October 29, 2021

**Re: KABQ CARGO FACILITY
2200 Sunport Blvd SE
Traffic Circulation Layout
Engineer's Stamp 10-18-2021 (P15-D004)**

Based upon the information provided in your submittal received 10-29-2021, the above referenced plan cannot be approved for Building Permit until the following comments are addressed:

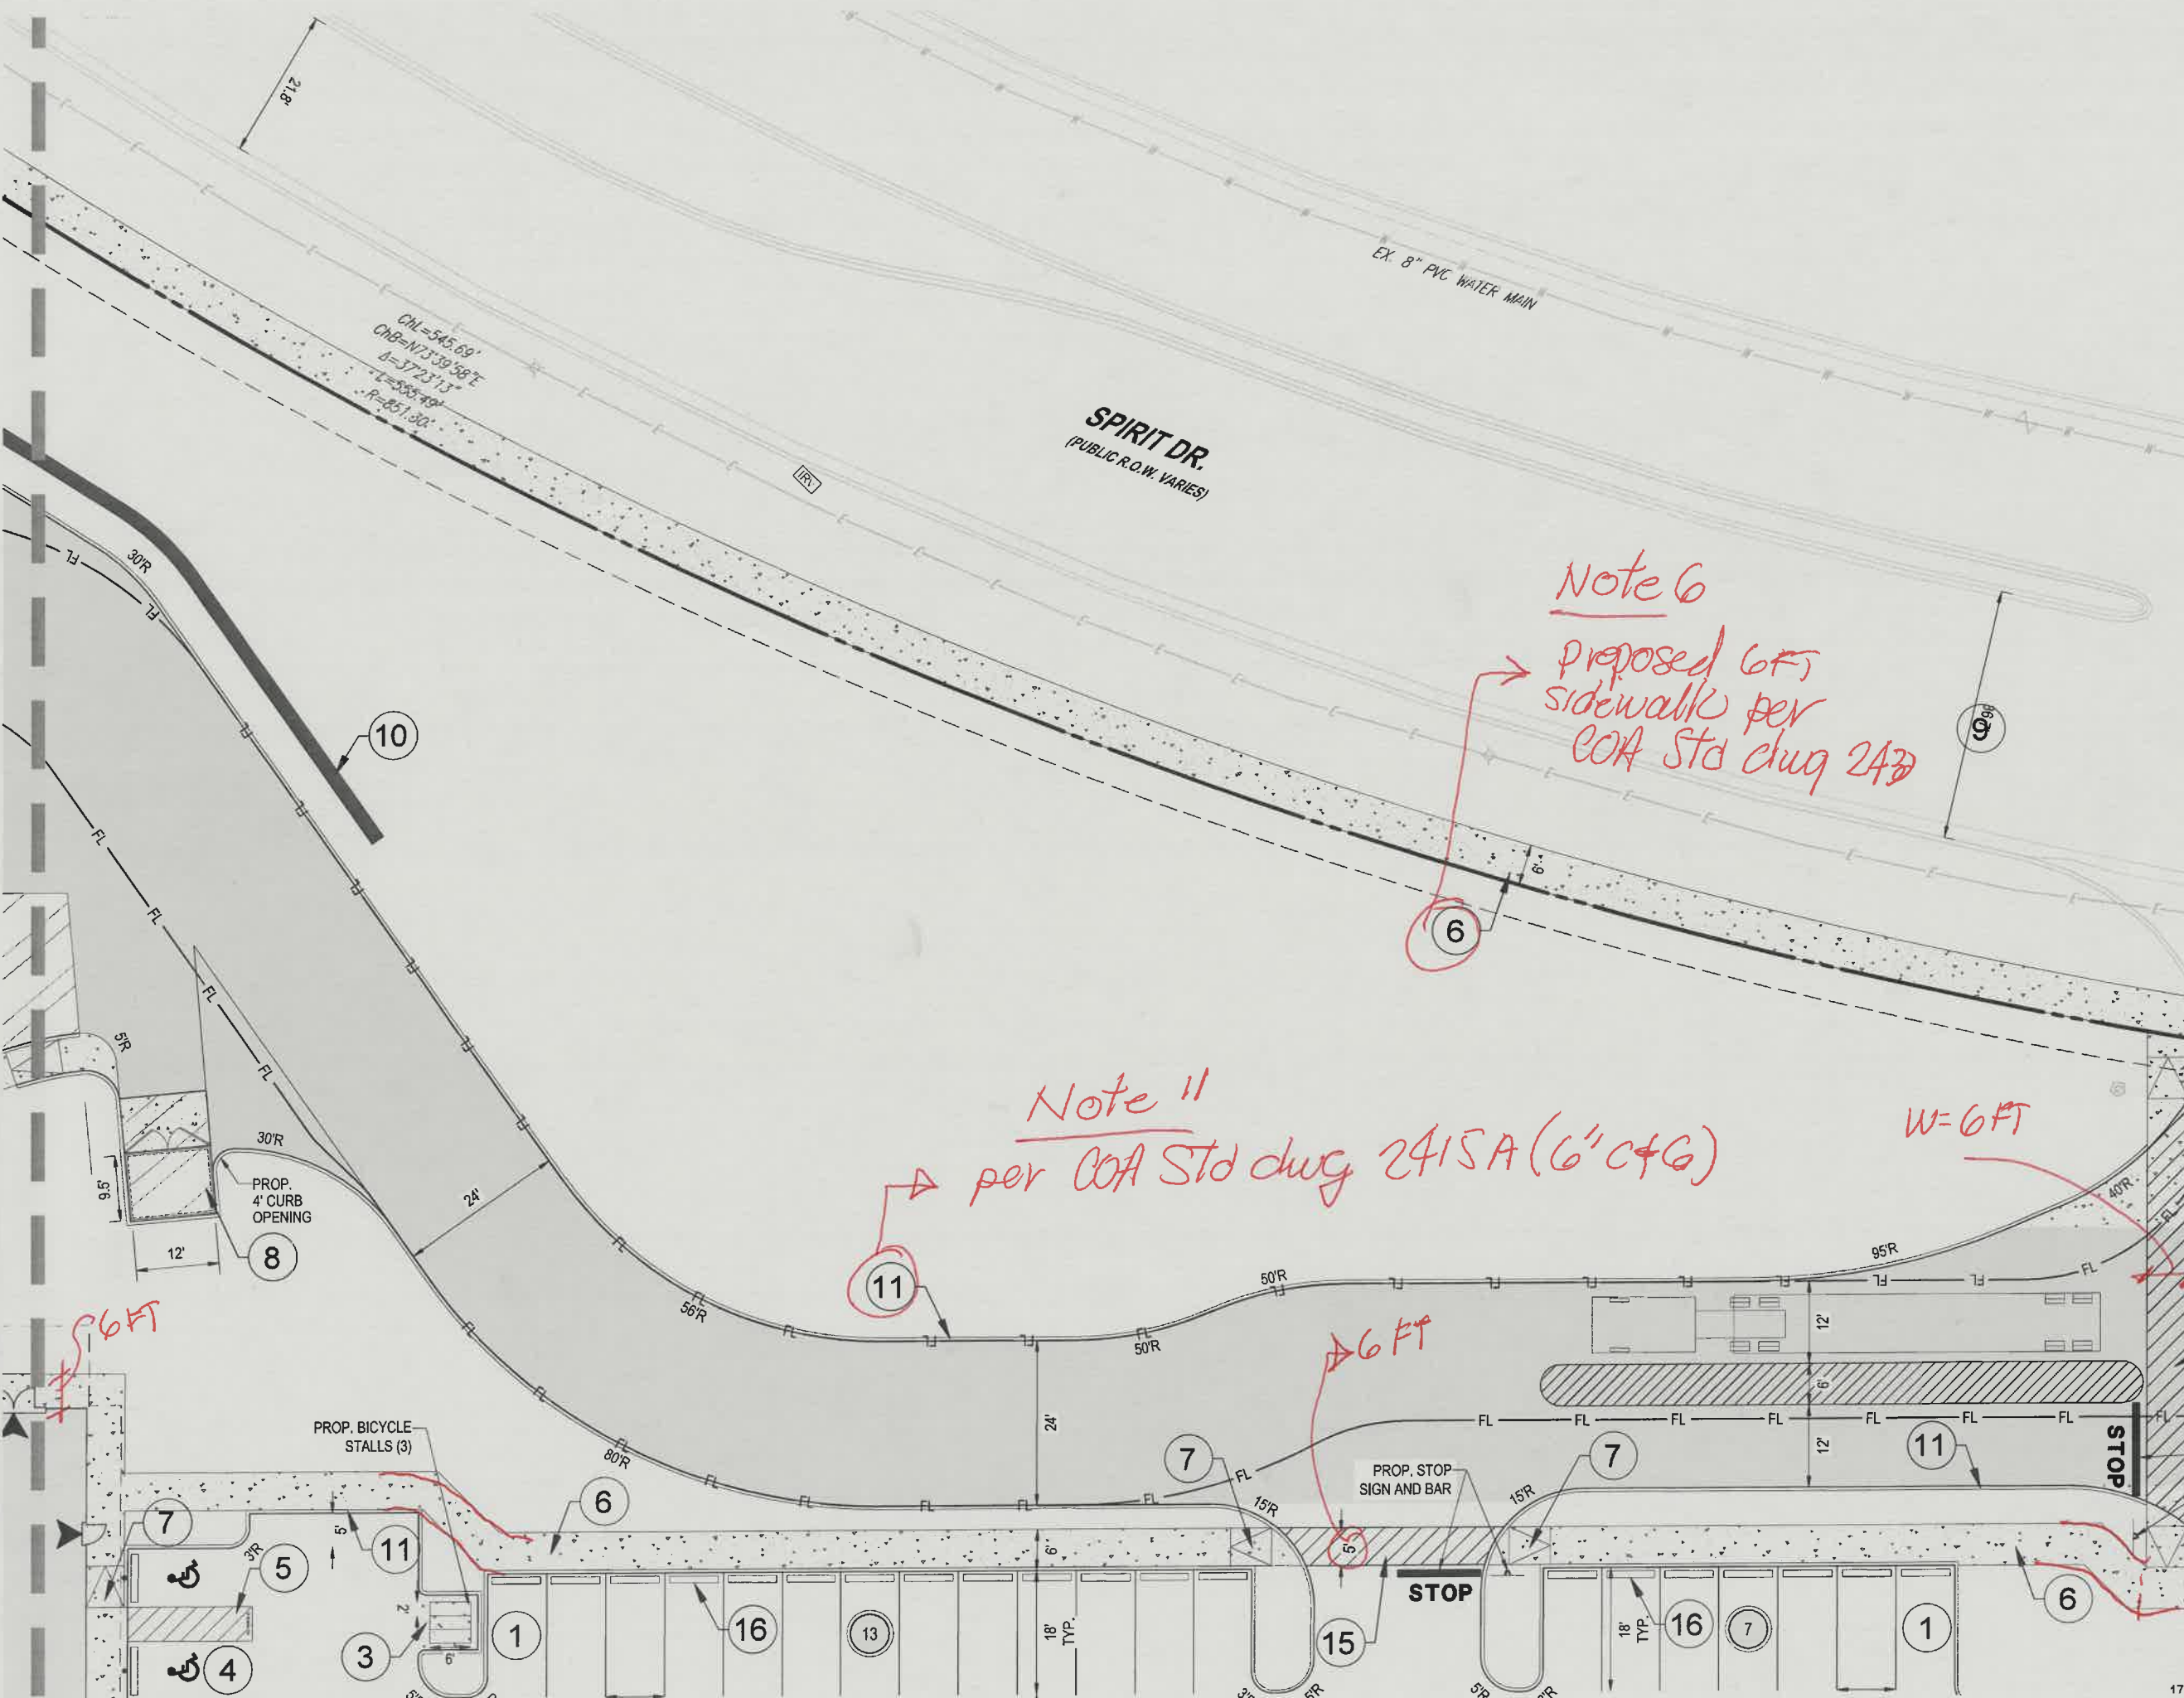
5. The ADA accessible parking sign must have the required language per 66-7-352.4C NMSA 1978 **"Violators Are Subject to a Fine and/or Towing."** Please call out detail and location of signs. **NOT ADDRESSED ON PRIOR COMMENT.**

7. ADA curb ramps must be updated to current standards and have truncated domes installed. **Details will need to be provided.**
8. Motorcycle parking spaces shall be designated by its own conspicuously posted upright sign, either free-standing or wall mounted per the zoning code. Label pavement MC. **NOT ADDRESSED ON PRIOR COMMENT**

9. Parking areas shall have barriers to prevent vehicles from extending over sidewalk,. **PROVIDE DETAILS OR REFERENCE DETAIL SHEETS ON SITE PLAN.**
10. Show the clear sight triangle and add the following note to the plan: "Landscaping and signage will not interfere with clear sight requirements. Therefore, signs, walls, trees, and shrubbery between 3 and 8 feet tall (as measured from the gutter pan) will not be acceptable in the clear sight triangle. **NOTE NEEDS TO BE ADDED.**

SEE ATTACHED SITE PLAN COMMENTS.
